Recommendation Report for Planning Permission for Works or Extension to a Dwelling

REF NO: P/36/22/HH

LOCATION: Sefter Cottage
Pagham Road
Pagham
PO21 3PX

PROPOSAL: Erection of two storey rear extension.

Drawing Number: 03

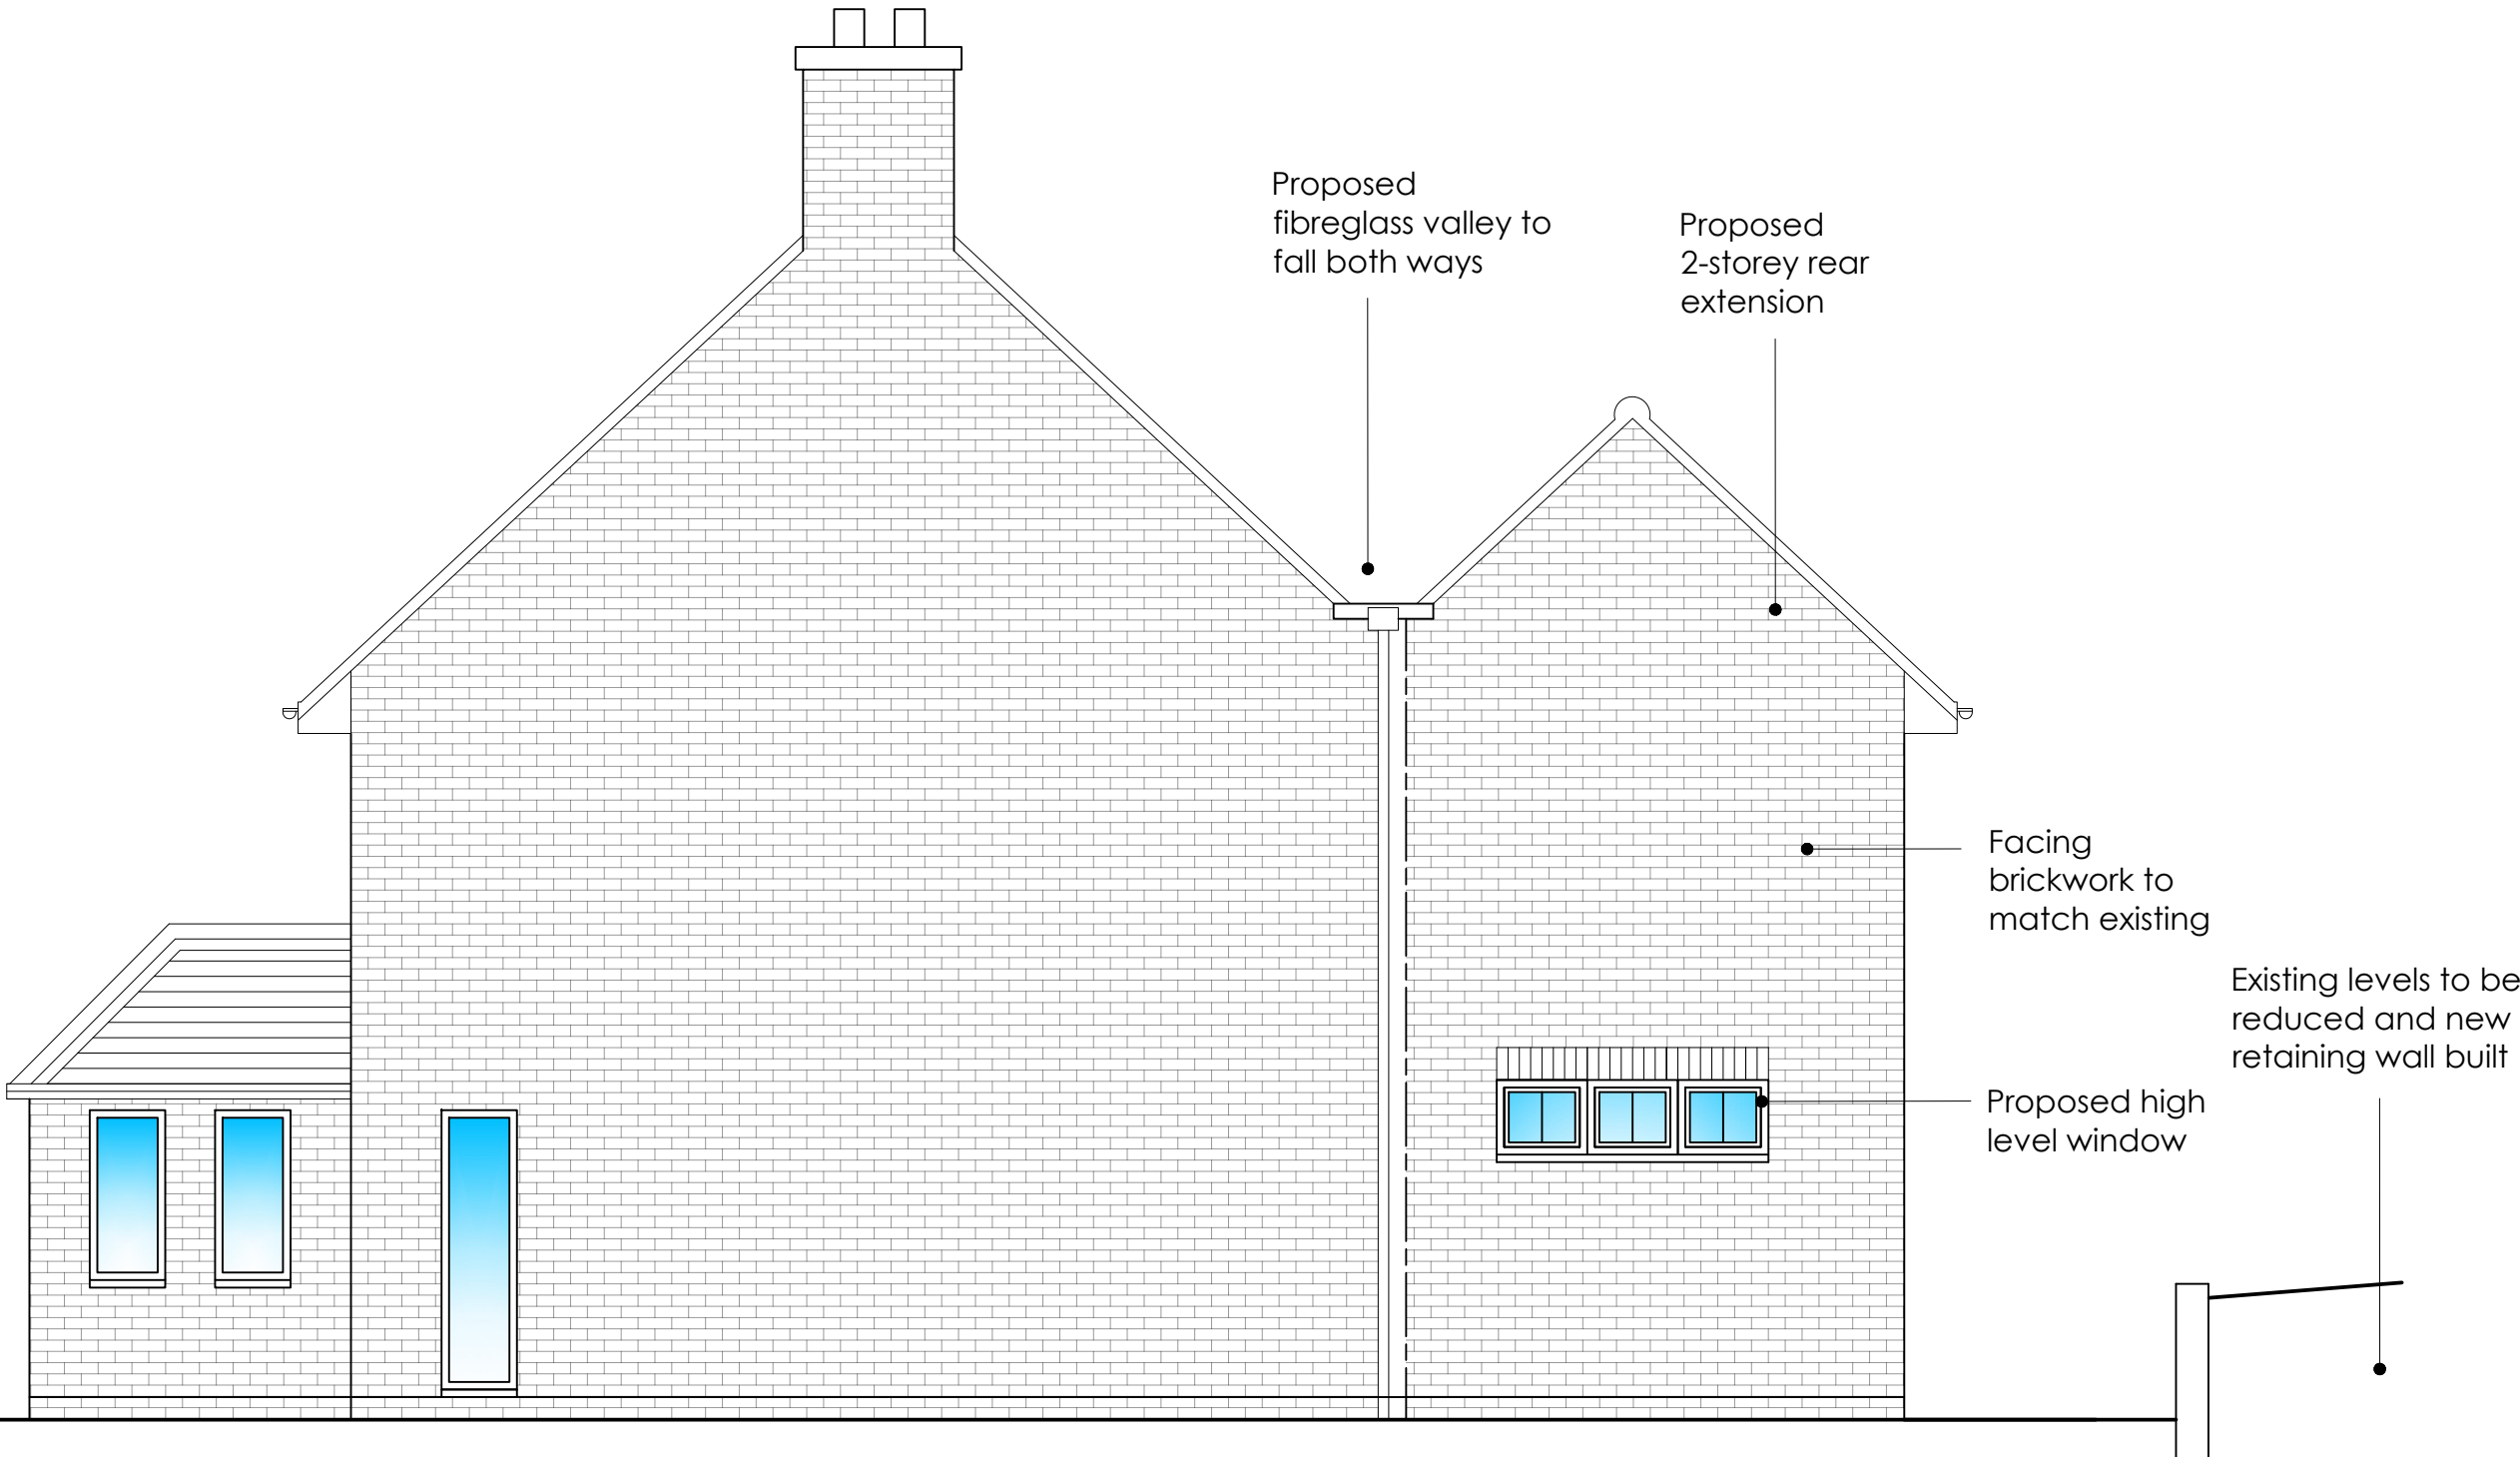
The extension has a modest depth at 3.3m. The extension is well integrated and features a pitched roof. This is set below that of the ridge of the main dwelling and helps to ensure the proposal appears a subservient addition.

The extension has a depth of 3.3m and run along the full rear elevation. The ridge will sit approximately 2.2m below that of the main property with the eaves meeting with the host dwelling.

The two storey addition will feature 4 first floor windows to the rear elevation. This will provide views over the rear garden of the property. Due to their position, any views over the neighbouring garden are largely restricted when looking at a 45 degree angle and would not result in adverse overlooking. There will also be one additional window serving a bathroom to the first floor northern elevation. The window will not give rise to any overlooking with no nearby dwellings to this elevation.
